MEMORANDUM

SUBJECT: SF-19-004 – Homestead Filing No. 2 Sterling Ranch
Third Submittal
LSC Response Below (3-3-2020)

Engineering Division

MAIL KIOSK GRADING DETAIL

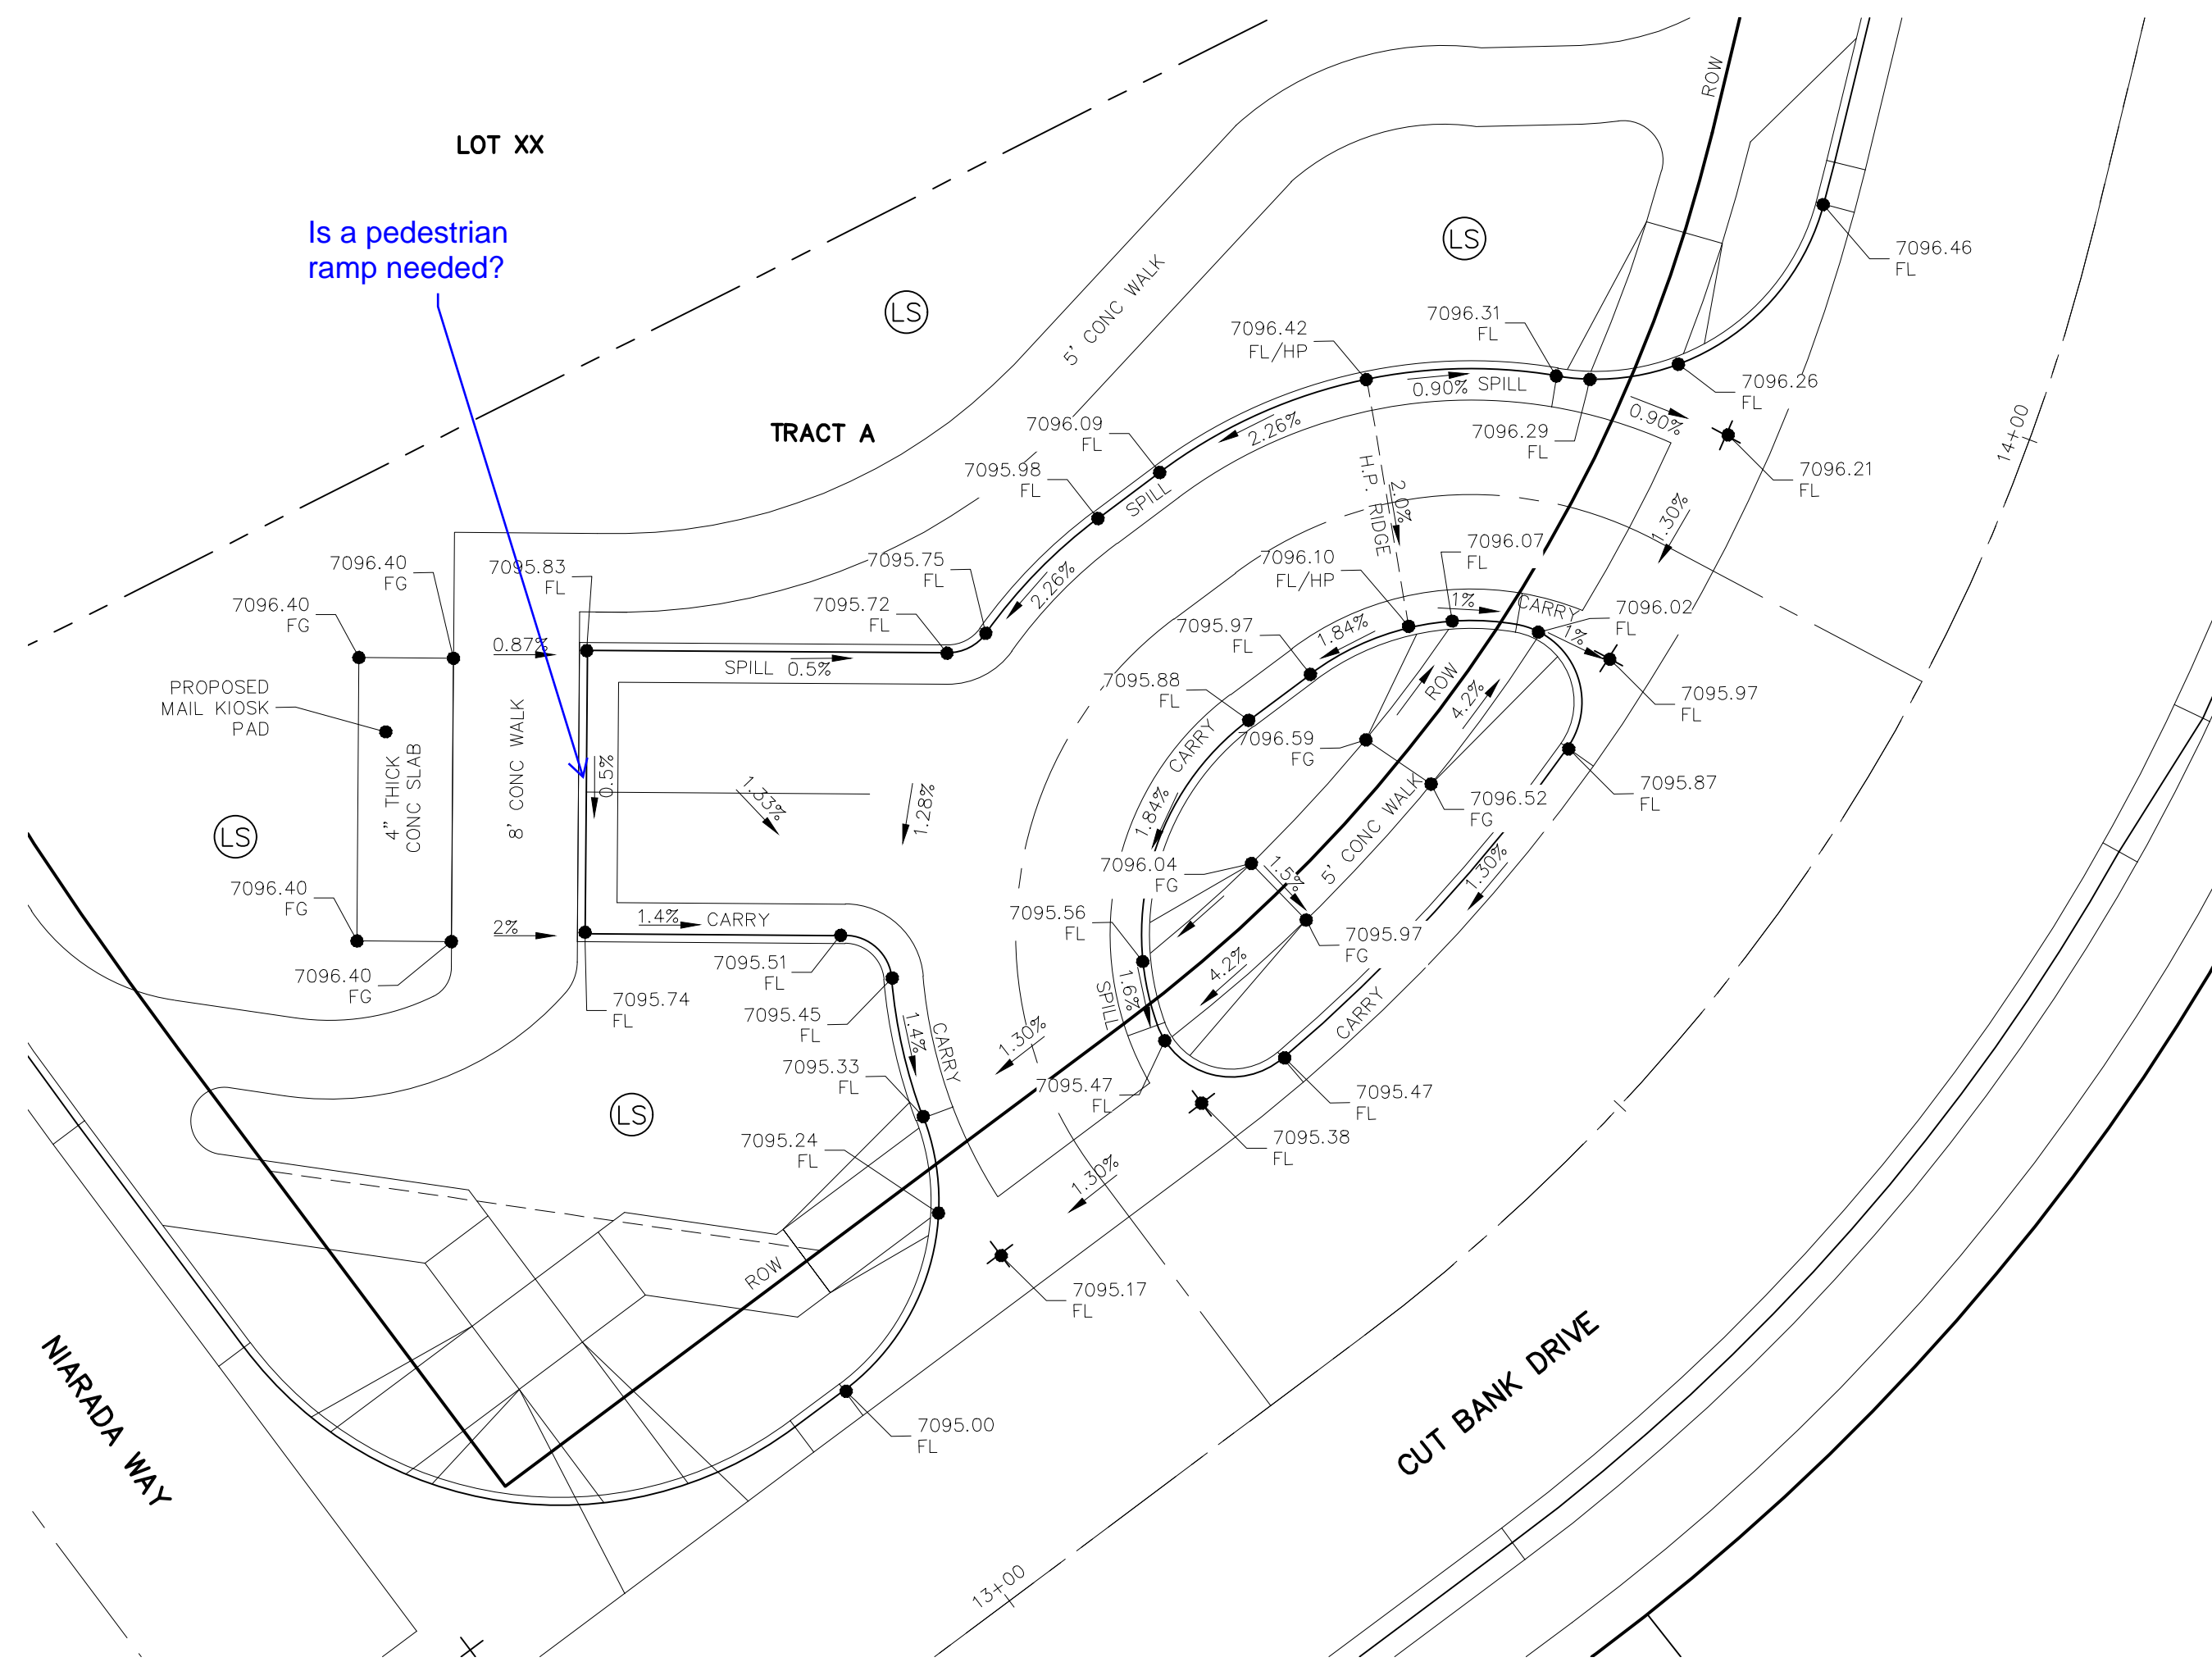
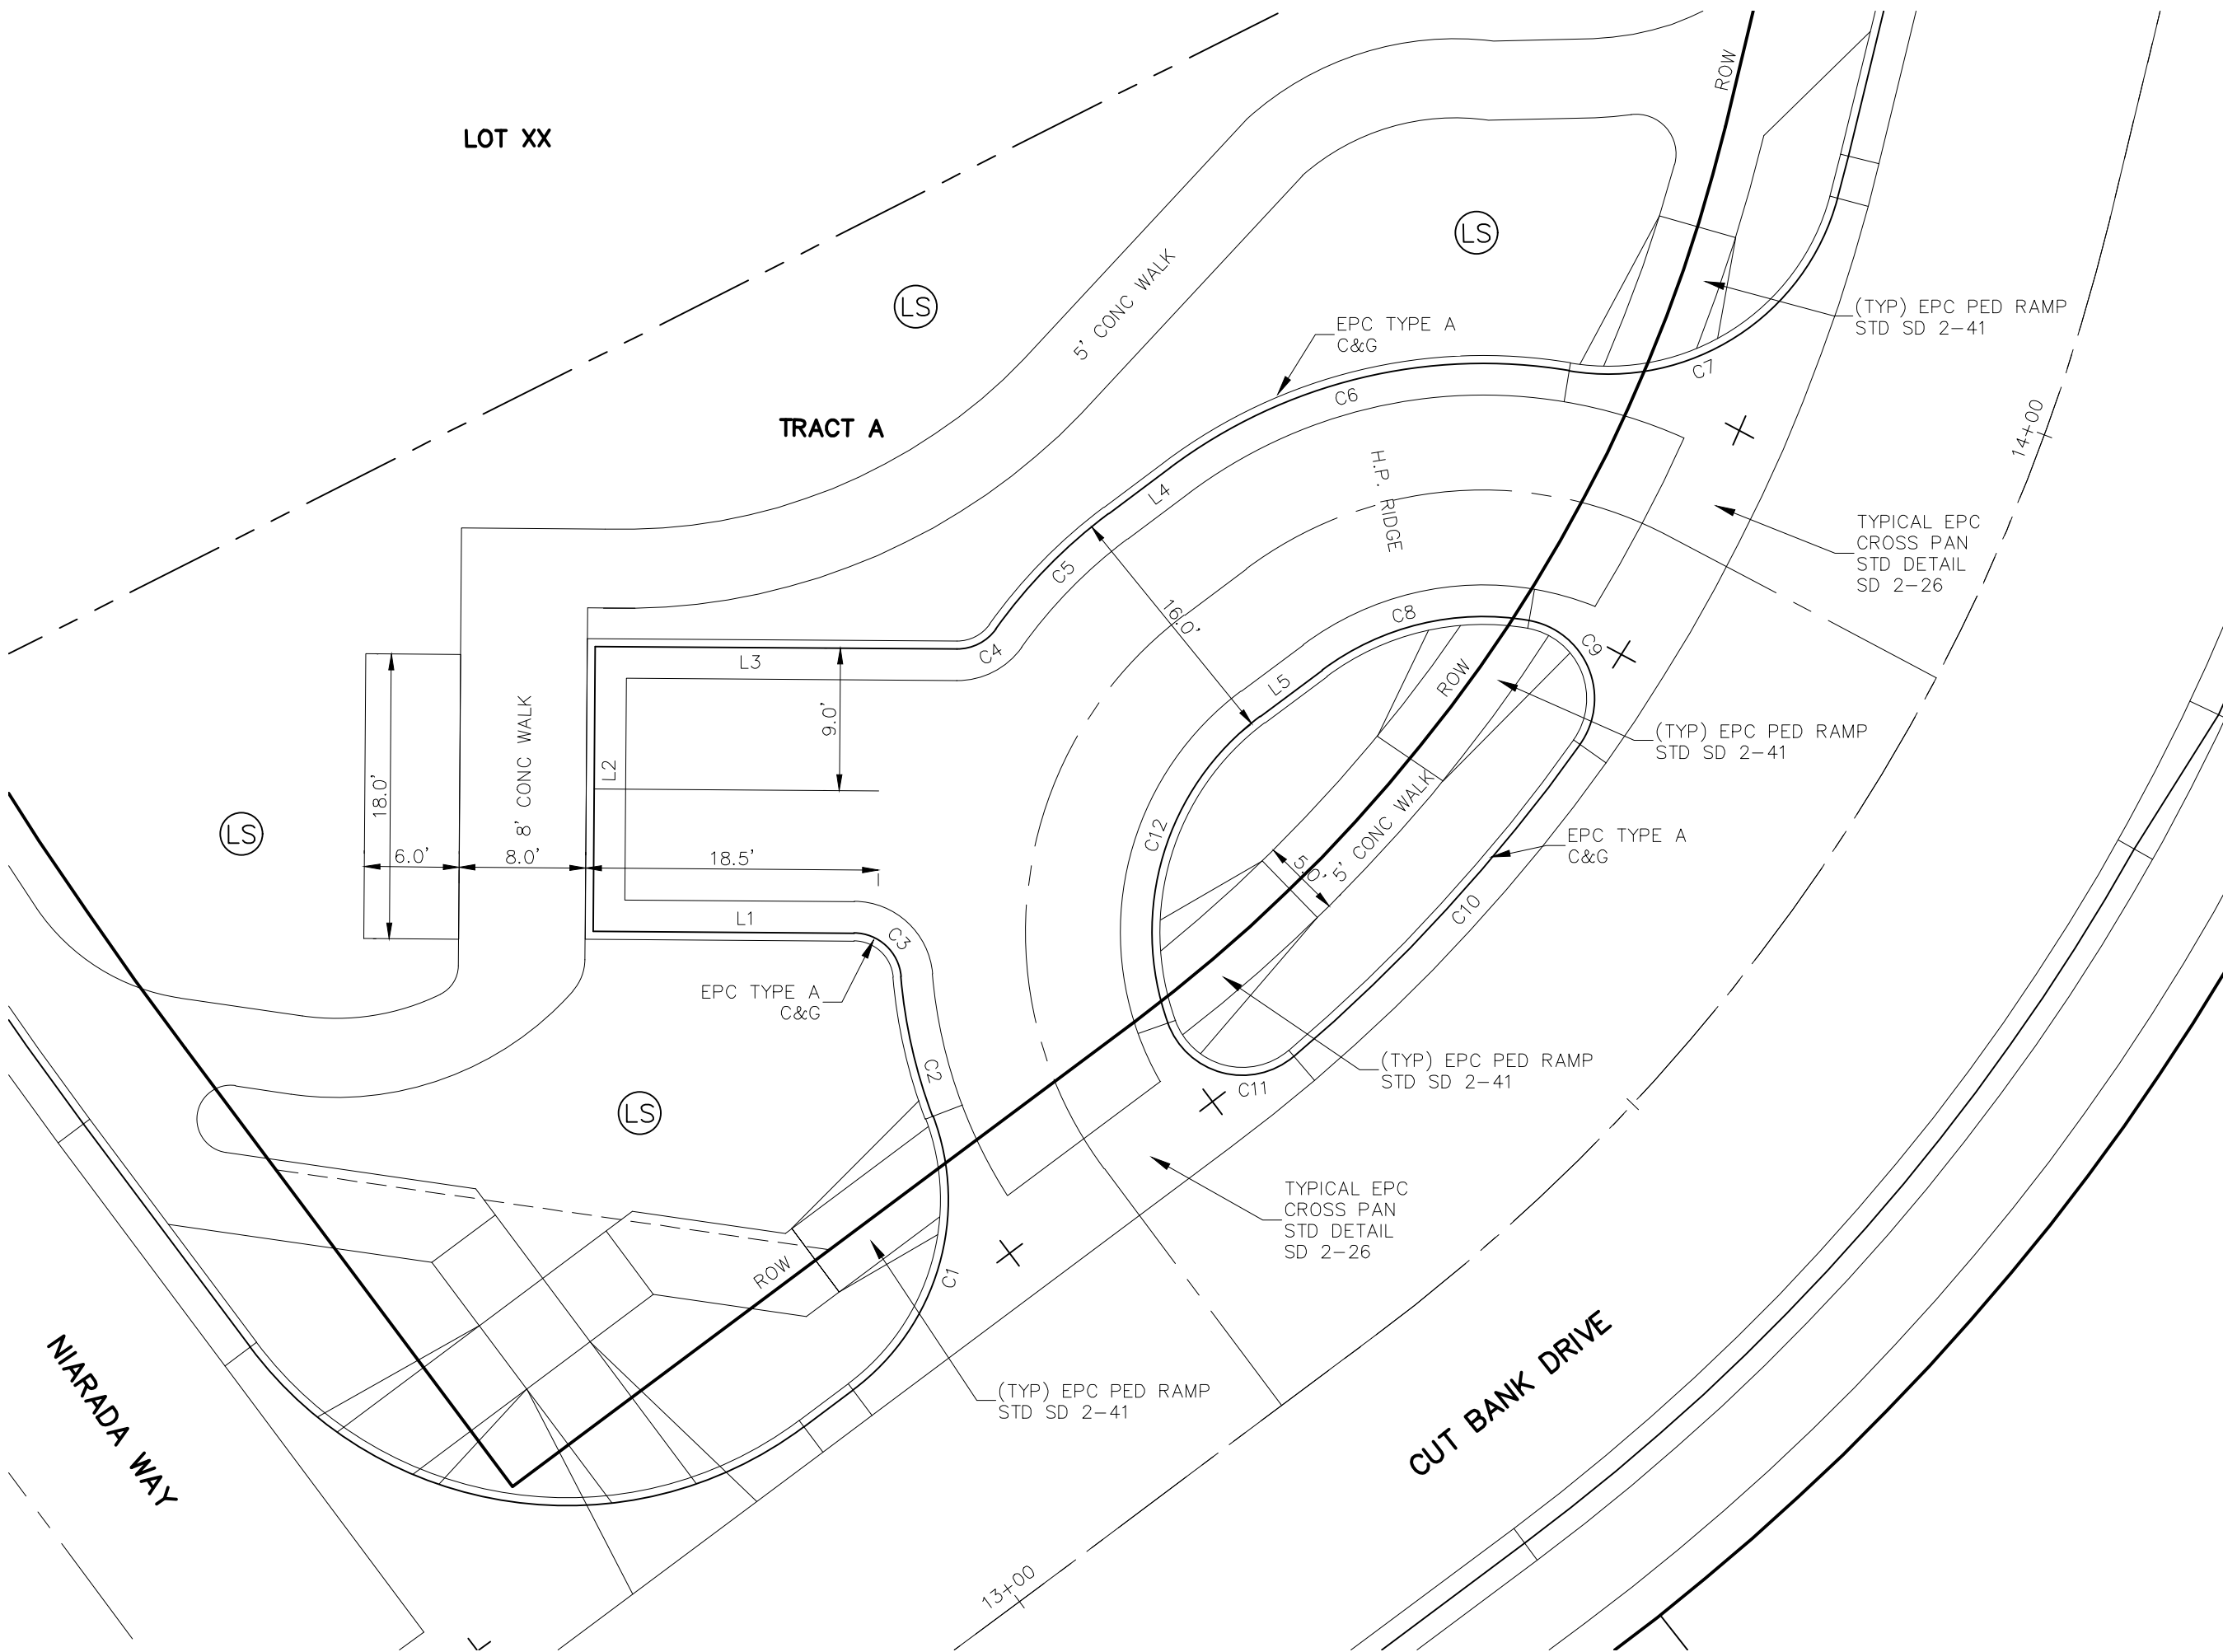
6. If there will be USPS mail kiosk/cluster(s) in this subdivision provide location(s) and details. **Partially resolved; provide detailed exhibit sheets (8-1/2" x 11") when available.**
